Proposed residential development at Hill top Farm, Redbrook Road, Barnsley.

We refer to our ongoing dialogue in connection with the above site and our meeting yesterday at the Civic Hall specifically to discuss the highways consultation response.

We are attaching an amended site layout plan revised where necessary and following discussion with our client, set out below our response to the questions raised by the highways officer.

proposed site layout plan 1:200

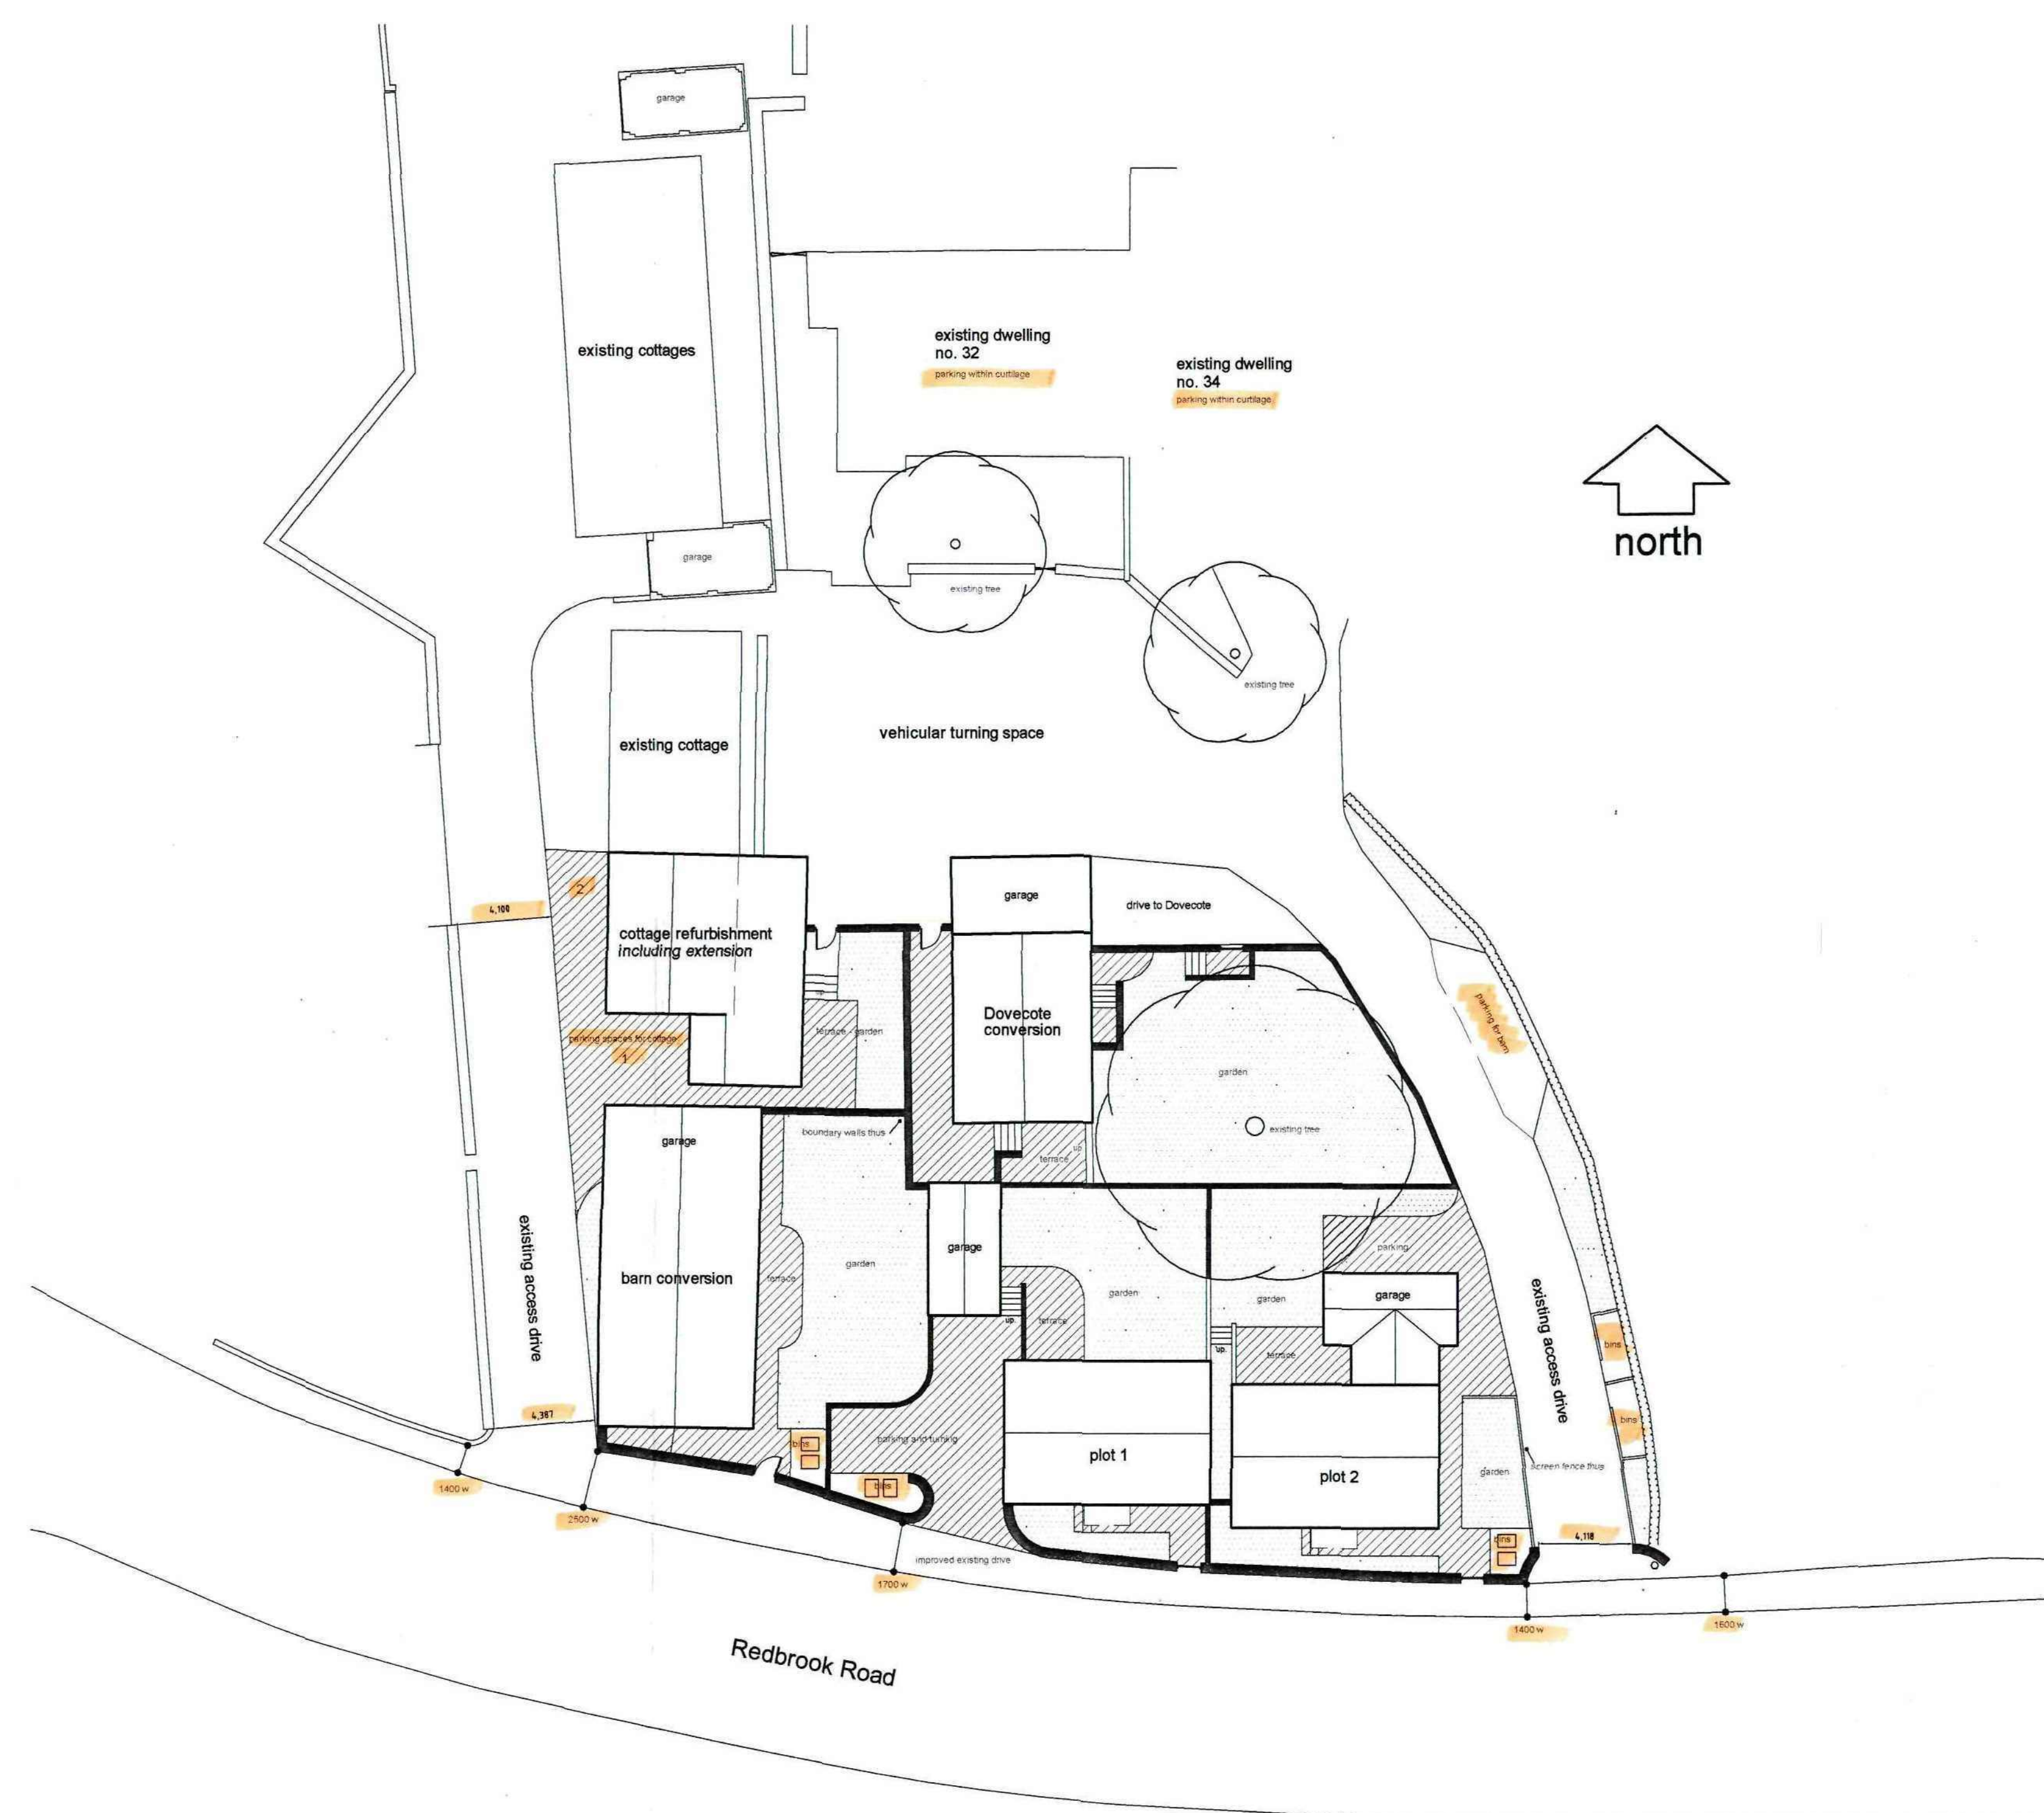
Parking:

The site plan has been revised to indicate the additional parking space to be allocated to the barn conversion and the refurbished and extended cottage.

Footway improvements:

The existing footway along the site frontage varies in width between 2.5 m and 1.4 m. To either side of the site frontage the footpath width is 1.4m to the west and between 1.7 m and 1.4 m to the east.

If the footpath was to be increased to 2.0 m wide across the site frontage it then reverts back to considerably less on either side. Widening the footway would involve a lot of work and would result in the new wall position approximately sitting with the outer face on the same line of what is currently the inner face. In other words, the wall is only moving back by it's own thickness. Our client questions the benefit of this bearing in mind the work involved could be described as disproportionate. He would ask that the wall be allowed to remain but reduced in height as required.

Visibility:

All walls and gated accesses fronting the highway will be lowered to a height not exceeding 1.05m.

Vehicular access:

Both shared accesses will be at least 4.1m wide for a minimum of 5m into the site and the dropped vehicle crossings widened to suit if required.

Bin collection areas:

Bin collection locations have been indicated on the revised site layout plan.

Access for emergency vehicles:

It is not intended to vary the existing turning facility to the north of the Dovecote.

The five dwellings that form the development could all be adequately accessed, all of which would be located within the 45m limit when allowing for a fire appliance to reverse no more than 20m along the existing access drives.
